RE: Johnson Short Plat, File Number SP-07-59

Kittitas County Community Development Services has determined that the Johnson Short Plat is a complete application and hereby grants **conditional** preliminary approval subject to the following conditions:

MEMORANDUM

TO: Mike Elkins, Staff Planner, Community Development Services
FROM: Randy Carbary, Planner II *rc*
DATE: June 5, 2007
SUBJECT: Johnson Short Plat

JOHNSON SHORT PLAT
PART OF SECTIONS 1 & 2, T. 19 N., R. 15 E., W.M.
KITTITAS COUNTY, WASHINGTON

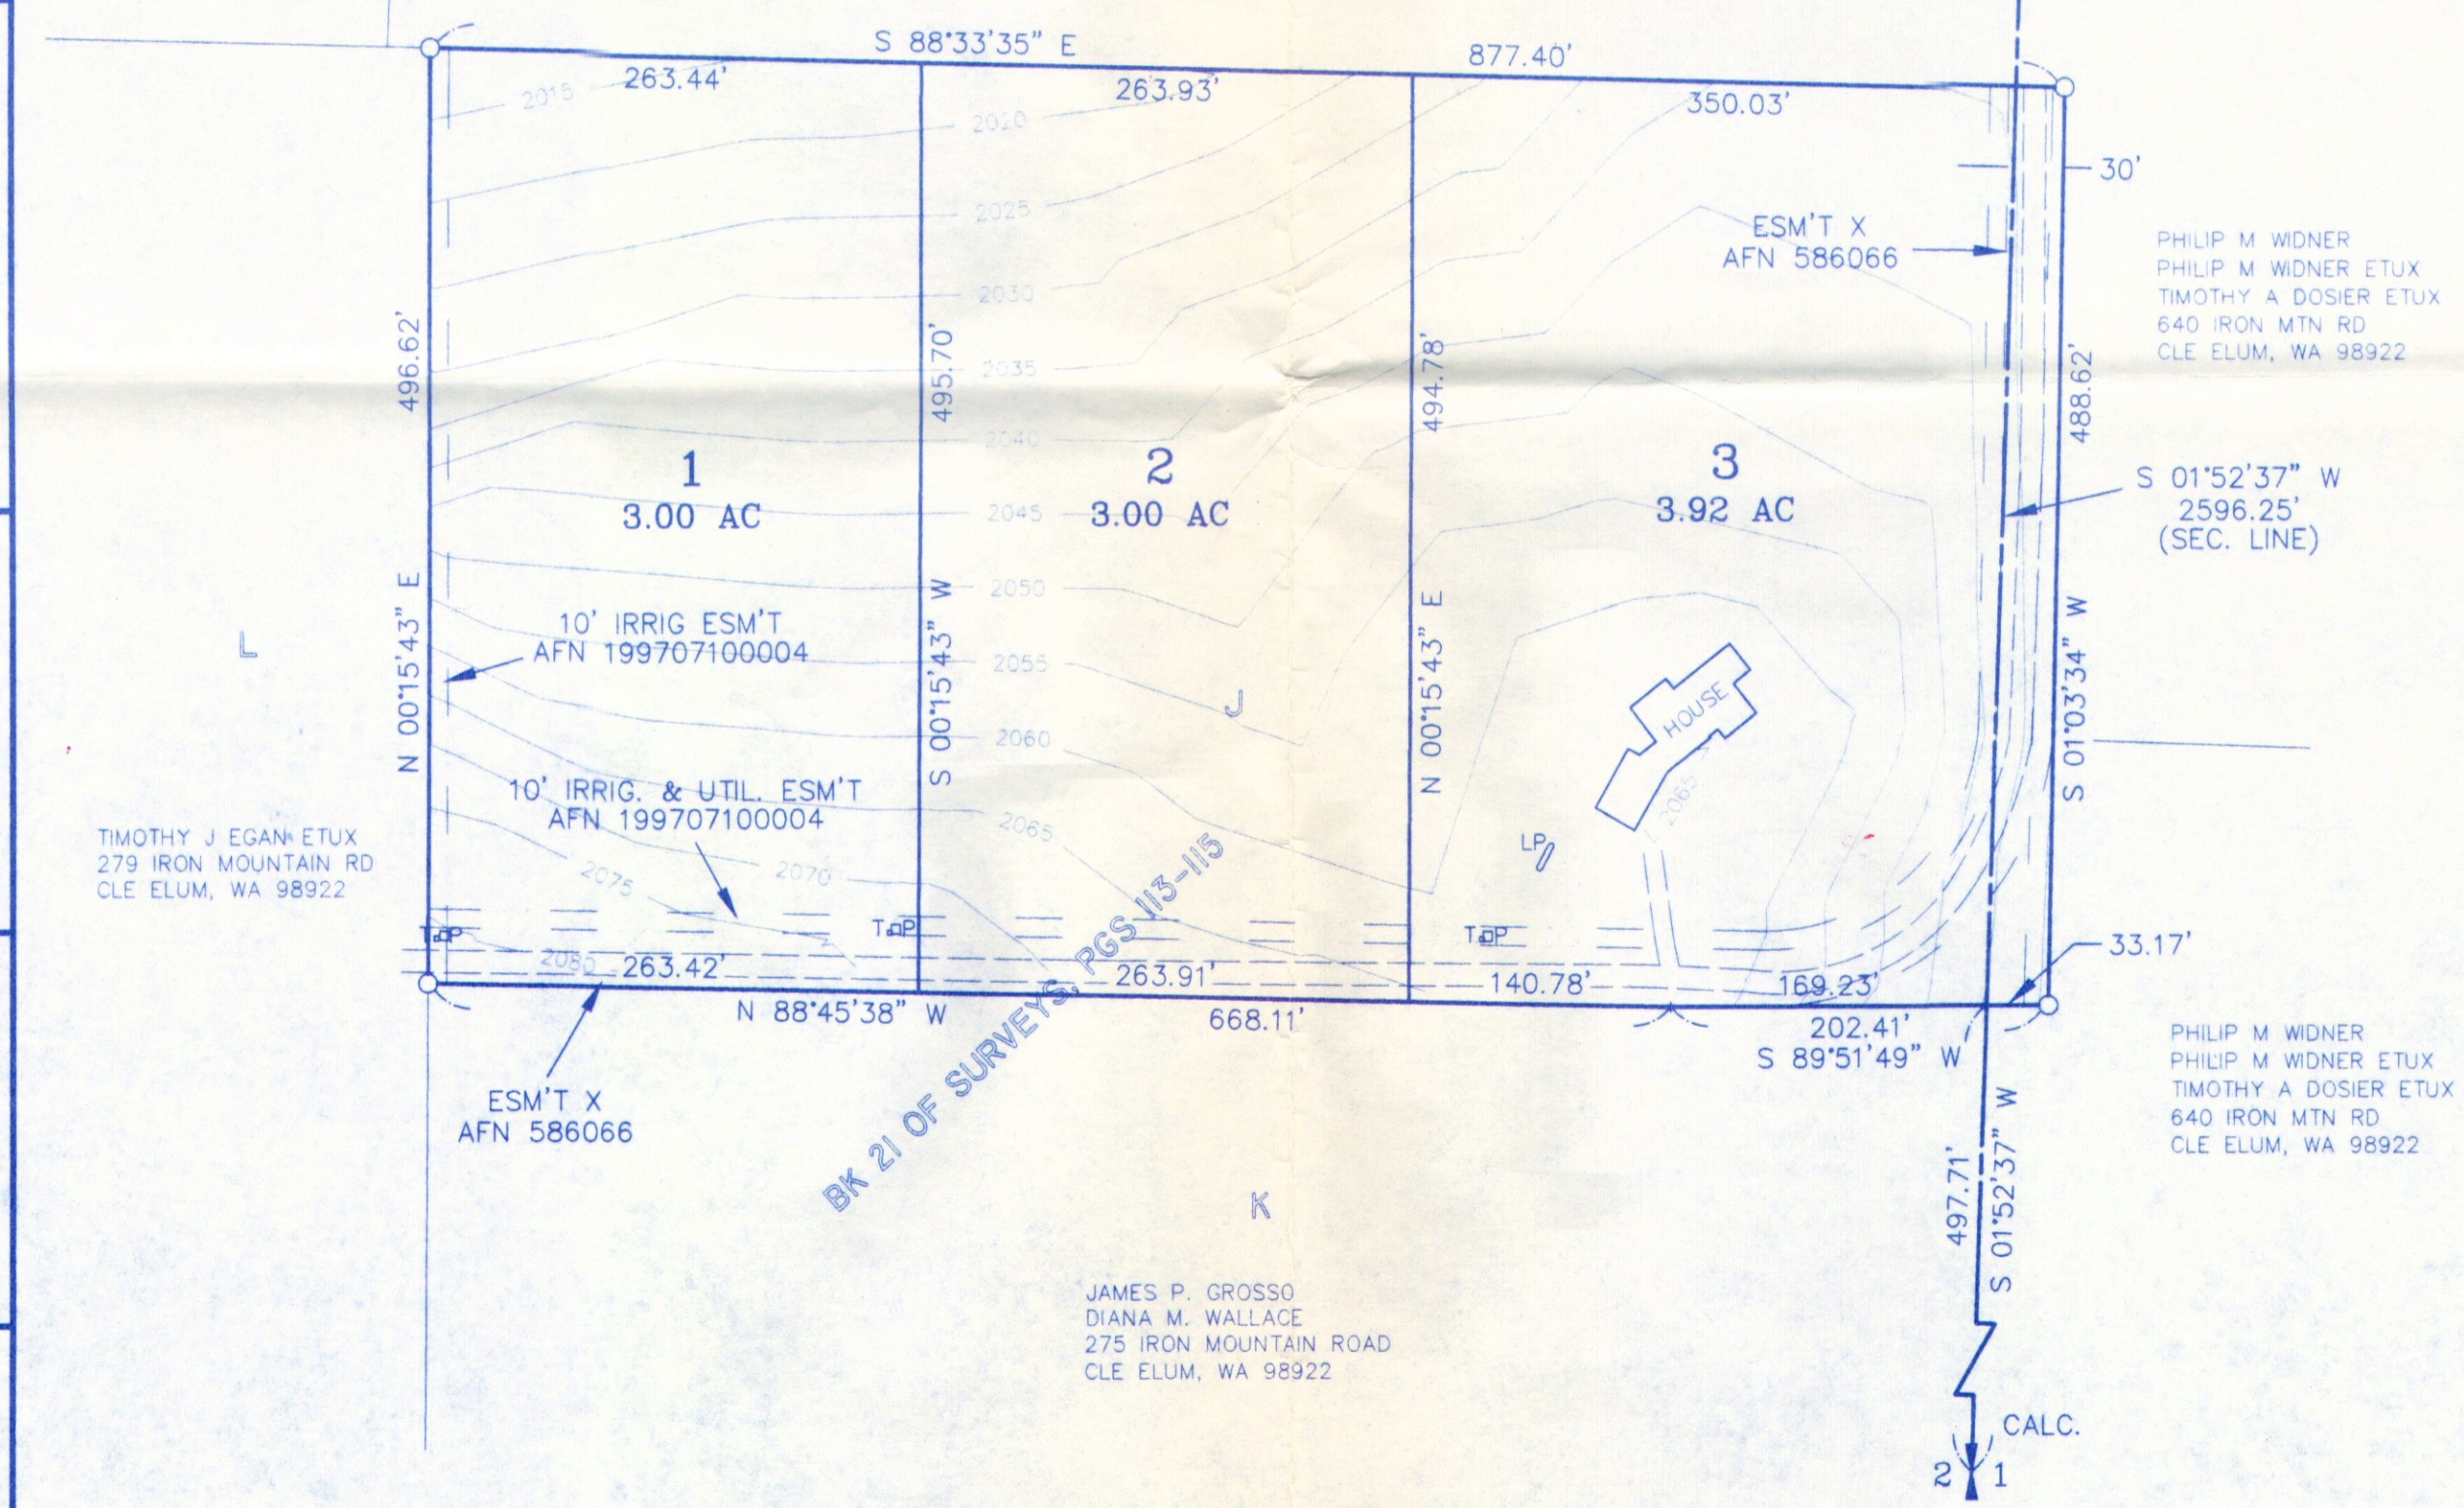
2. Access Easement: The proposed access easement for Iron Mountain Road shall meet or exceed the 60' width requirement for a high-density road prior to the issuance of a building permit for any of the structures within the proposed plat.

4. Private Road Improvements: The proposed access easement for Iron Mountain Road shall be constructed as a High-Density Private Road and serve no more than 40 tax parcels. See current Kittitas County Road Standards, 9/6/05 edition.

- a. Access easements shall be improved to a minimum of 60' wide. The roadway shall have a minimum width of 22', with 1' shoulders, for a total width of 24'.

- j. All easements shall provide for AASHTO radius at the intersection with a county road.
5. Cul-de-Sac: Permanent dead-end streets shall have a turn-around having an outside right-of-way easement diameter of at least 110' (55' radius) at the closed end. See

Kittitas County Road Standards, 9/6/05 edition. The location of the cul-de-sac shall be shown on the final mylar.

- a. Cul-de-sac design, reference AASHTO.
 - b. Contact the Fire Marshall regarding any additional cul-de-sac requirements.
6. Access to Lot 3 Private Road Improvements: The proposed access to lot 3 shall meet or exceed the high-density road requirements as shown below. Access shall be constructed as a High-Density Private Road and serve no more than 14 tax parcels prior to the issuance of a building permit for any of the structures within the proposed short plat. Any further subdivision or lots to be served by proposed access may result in further access requirements.

- a. Access easements shall be a minimum of 40' wide. The roadway shall have a minimum width of 20', with 1' shoulders, for a total width of 22'.
 - b. Minimum centerline radius will be 60'.

- j. All easements shall provide for AASHTO radius at the intersection with County Road.
7. Access to lots 1 and 2 Joint-Access Driveway: Access to lots 1 and 2 shall be via the access easement X, as shown on the face of the plat. The joint-use access shall serve no more than two tax parcels.

- a. Access easements shall be a minimum of 20' wide. The roadway width shall have a minimum width of 12'.
 - b. The surface requirement is for a minimum gravel surface depth of 6".
